12th August 2017

Replace two storey rear extension & erection of rear balcony & external staircase. 2 Elmer Court Middleton on Sea

Ref M/62/17/HH - Mr A Wood and Mr N Crowther

Ground Floor Plan

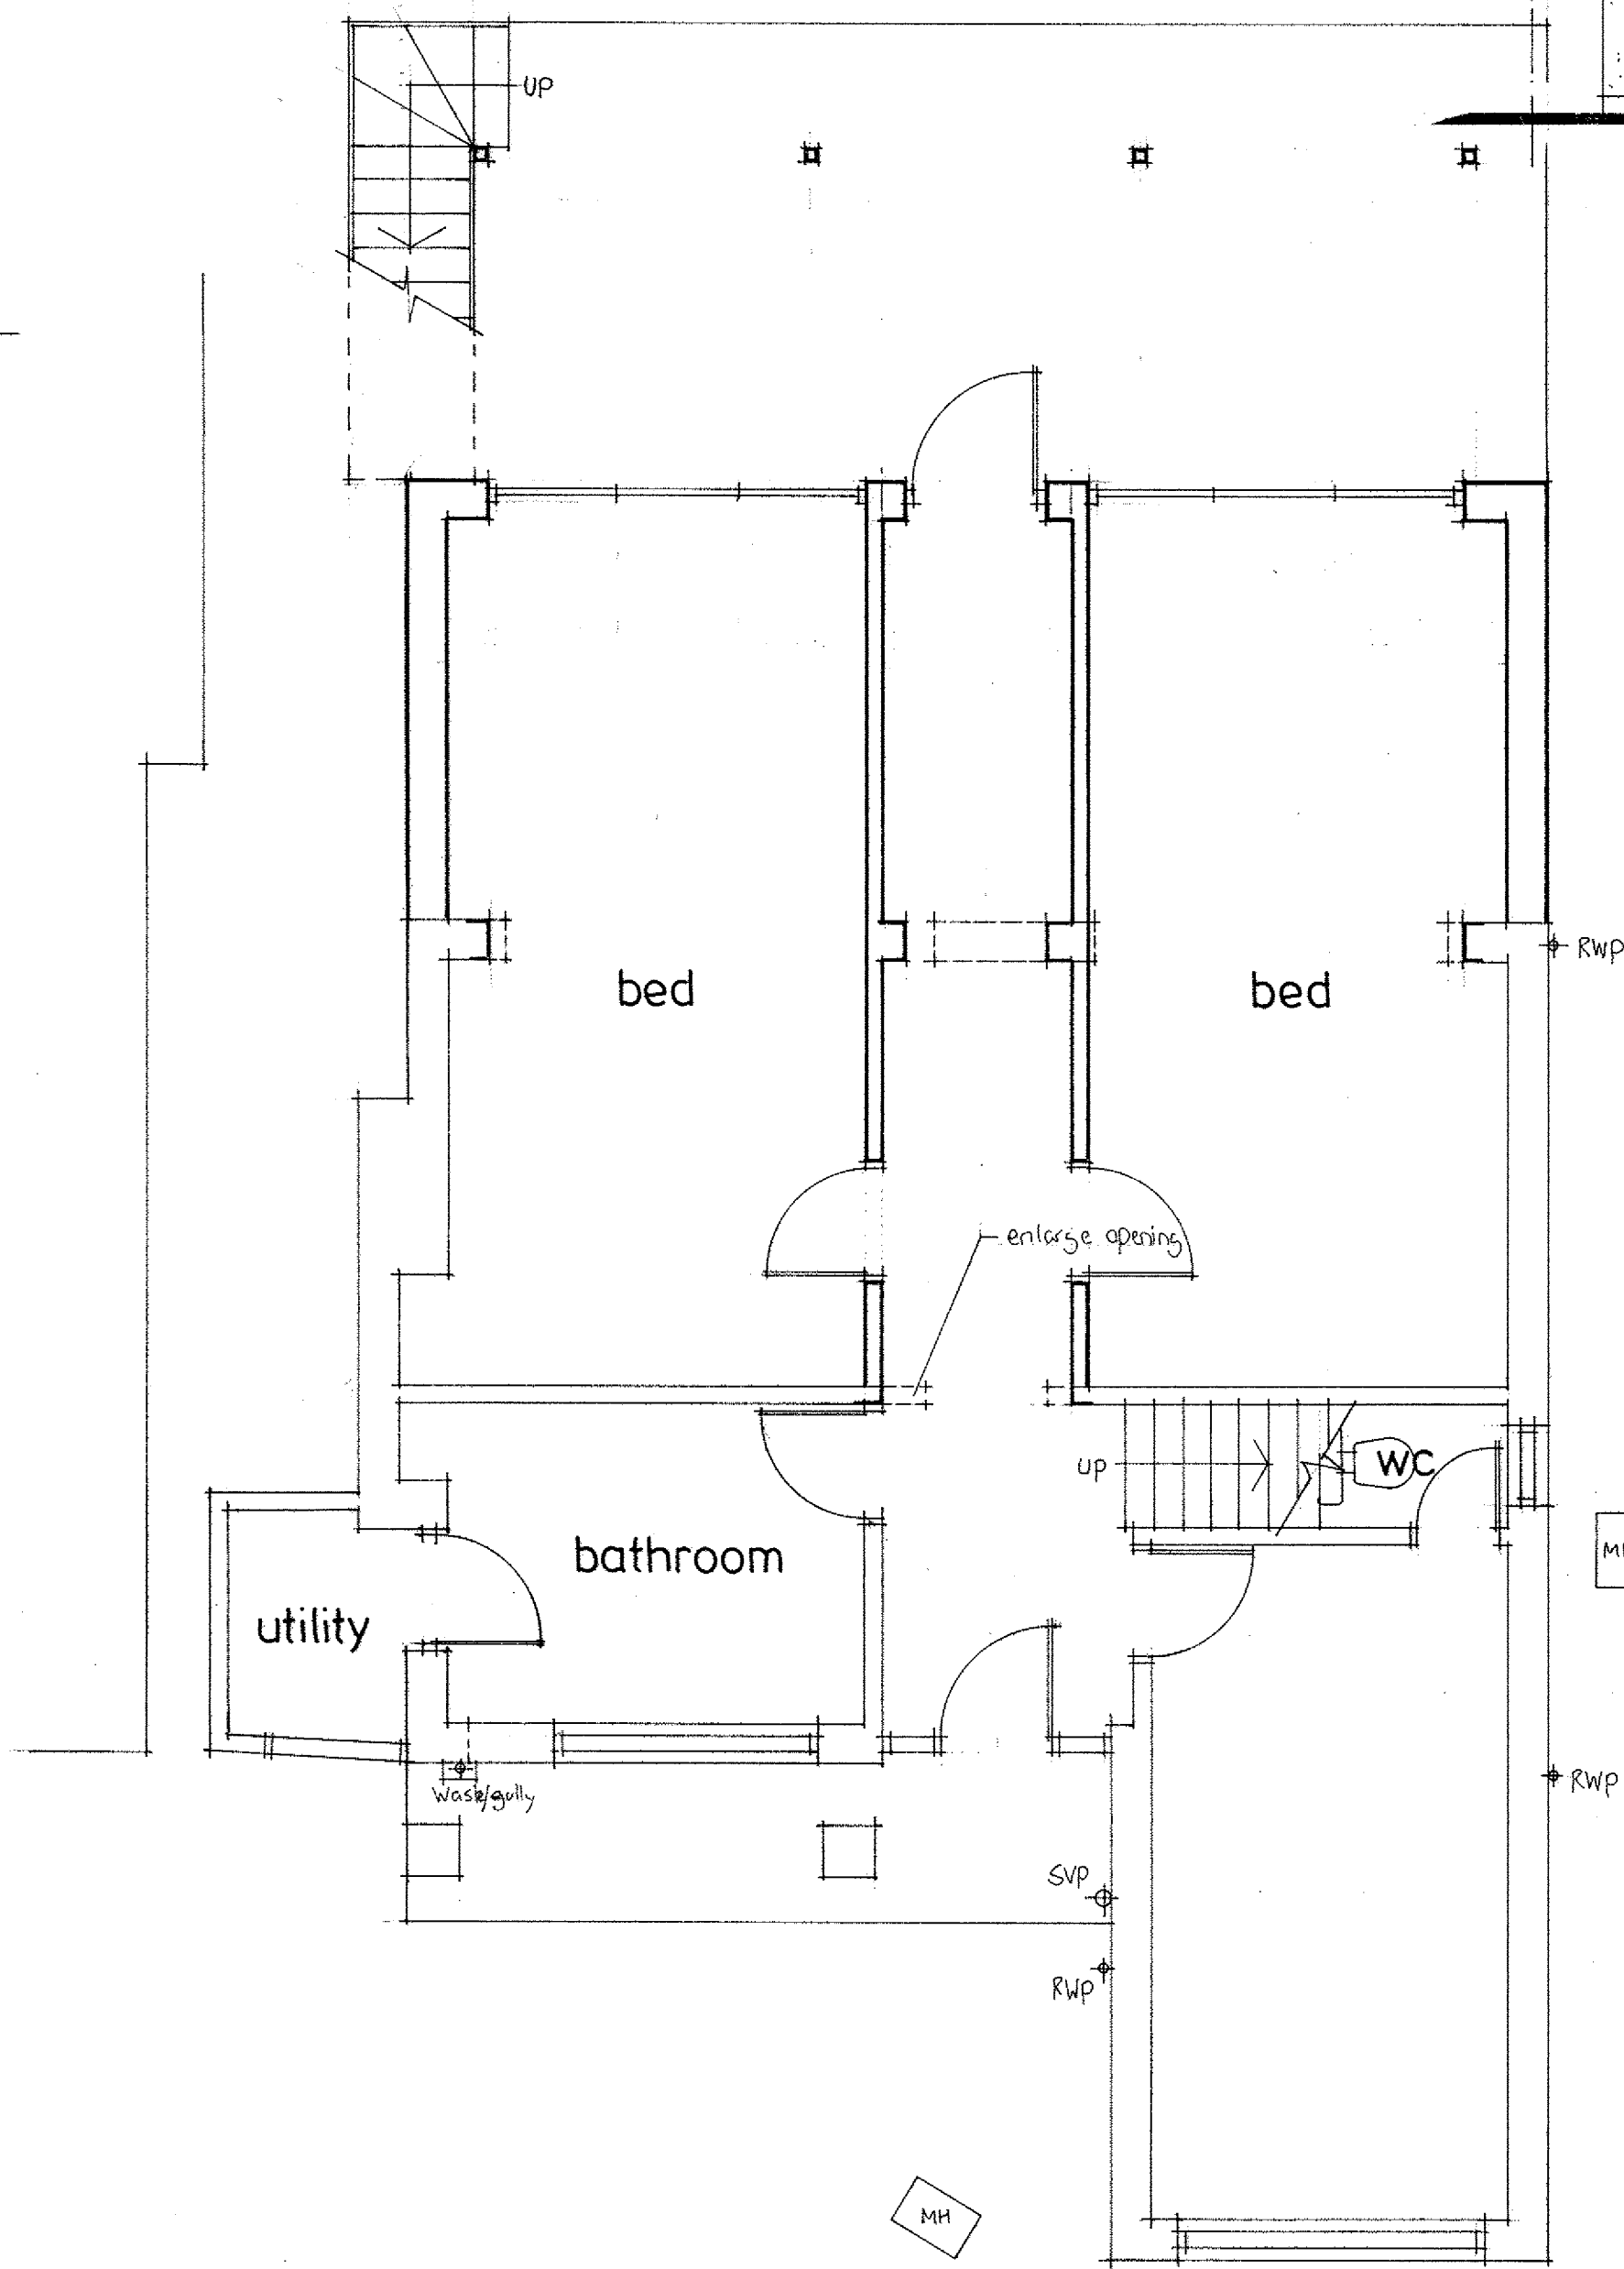
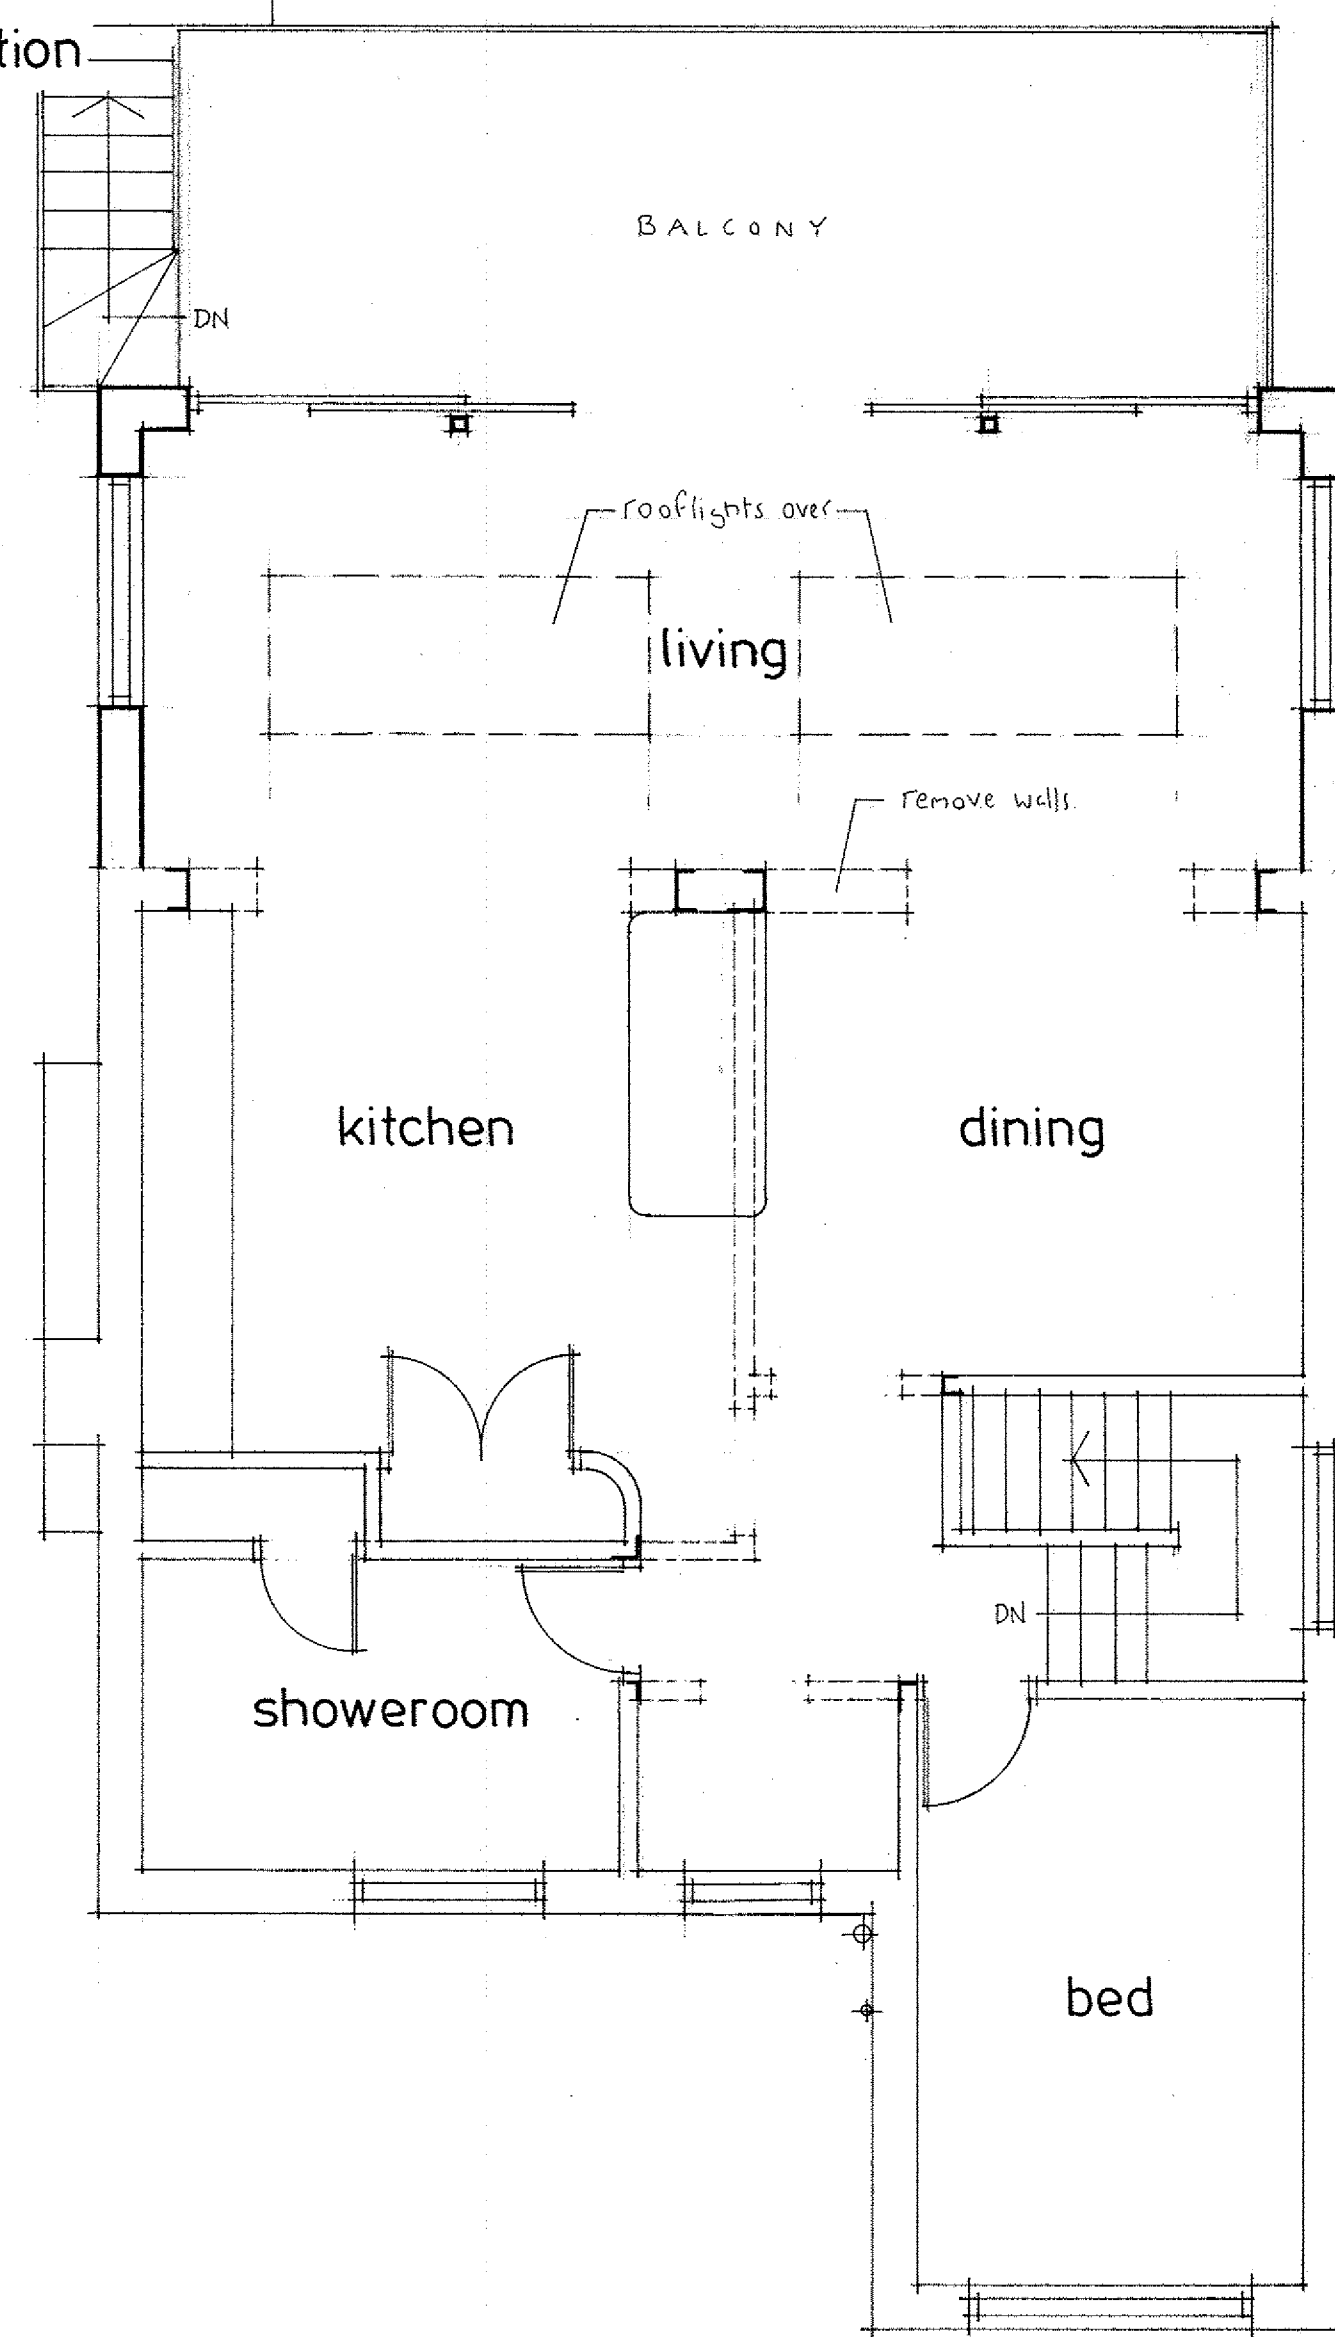
We would also like to point out that according to the floorplan the walls of replacement extension will be moved closer to our boundary, further increasing the above effect.

We assume from the floorplan that the rebuild of the extension includes moving the

wall of the extension closer to our property to align with the wall of the main building wall. This would mean the new extension will be bigger than the existing footprint by at least two length of bricks. As a result we assume new foundations will be required which in turn would require a party wall agreement for the works to proceed. If the extension were to be approved we would expect to receive a party wall notice.
